MEMORANDUM

TO: All Staff
FROM: Justin Turnbull, County Surveyor
DATE: March 24, 2017
SUBJECT: County Survey Review of Boundary Line Adjustment 17-00001 (Gibb)

**SHEET 2 OF 2**

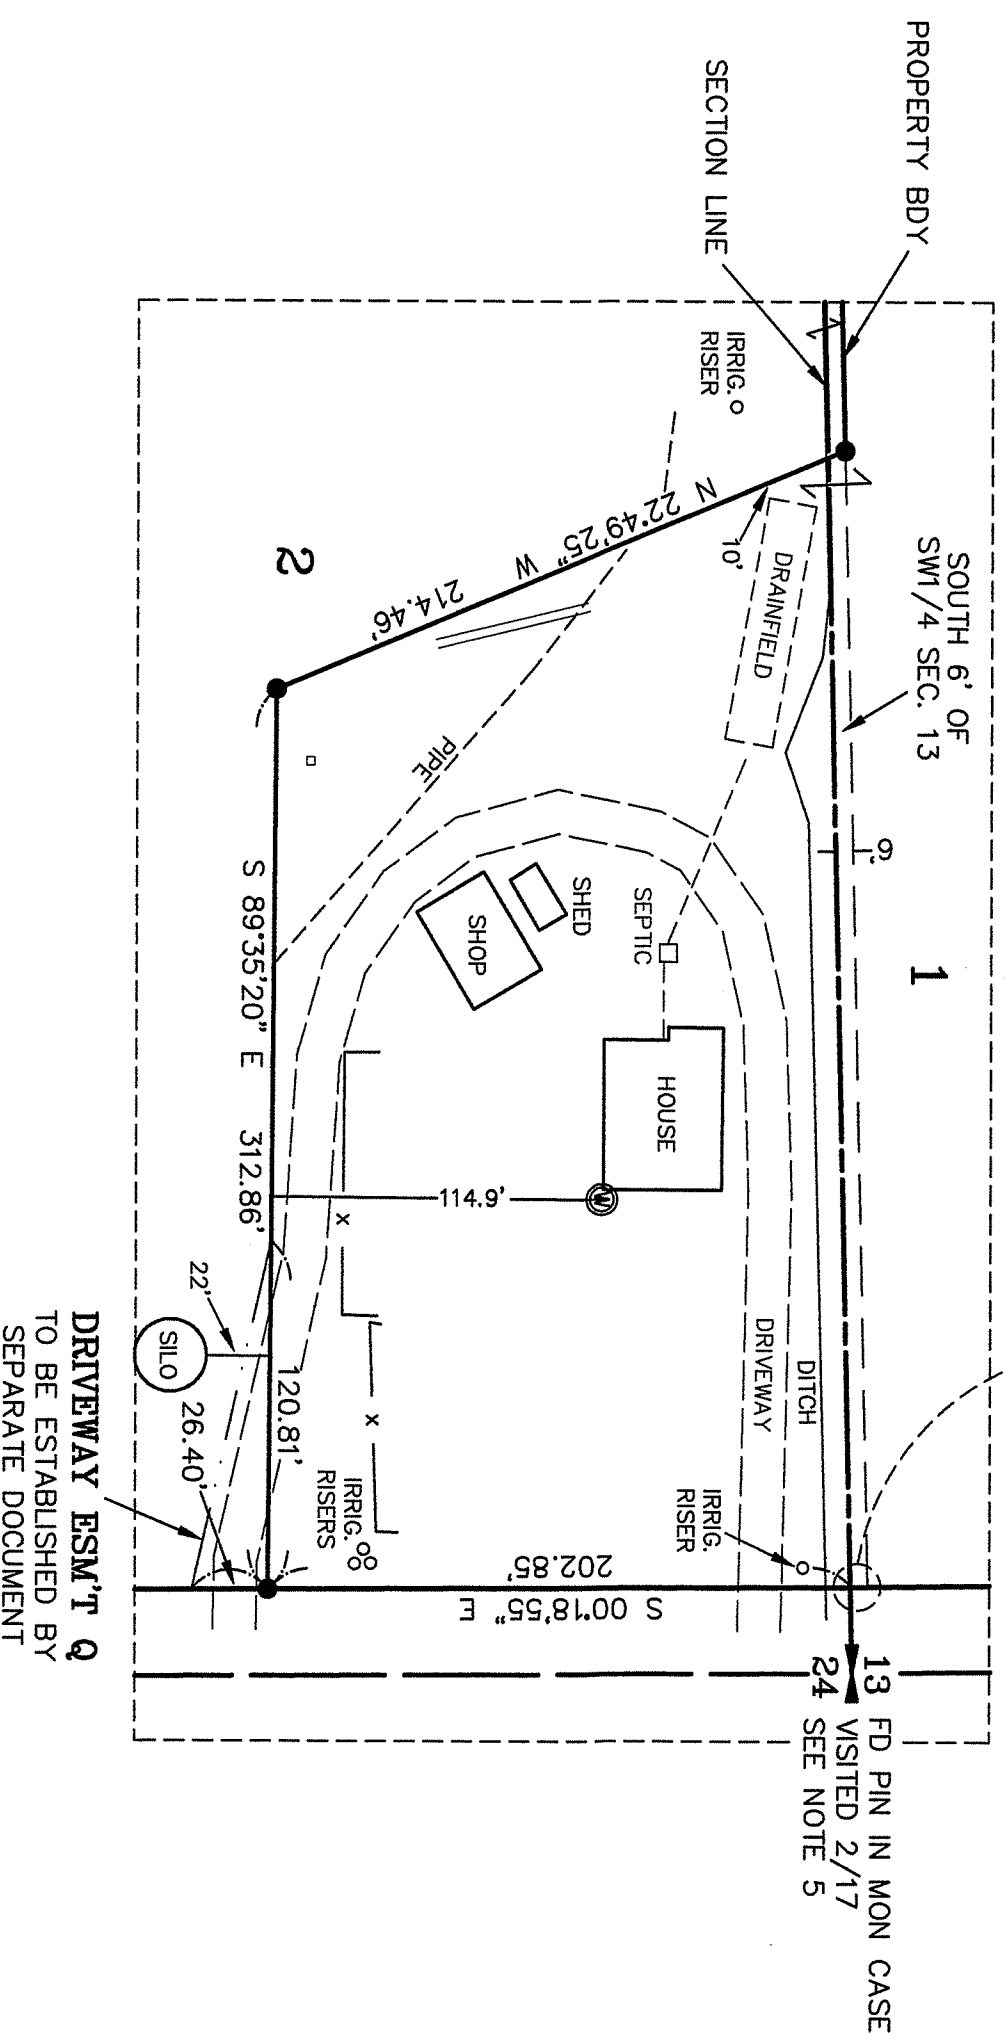
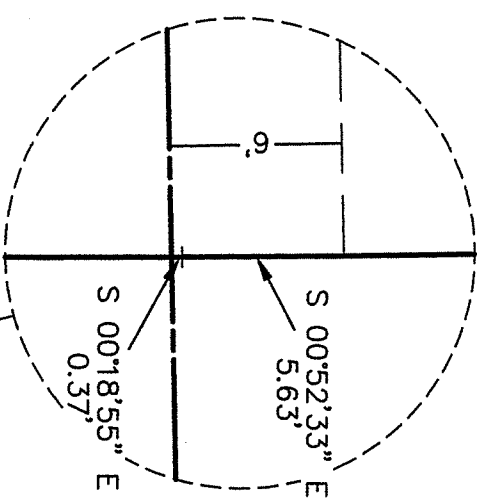
1. The Basis of Bearing does not reference a recording number. Reference Book and Page OR Auditor's File No. for Basis of Bearings.
2. Please include Visit Date on the Monument located at the North Quarter Corner of Sec 24.
3. The North Quarter Corner of Section 13 references a document that does not include said monument.
4. Sheet 2 should note the "Previous Boundary" (or similar).
5. The notes should contain a "purpose of survey" statement together with the application number.
6. Line 2 of Easement Q description contains a minor typo.
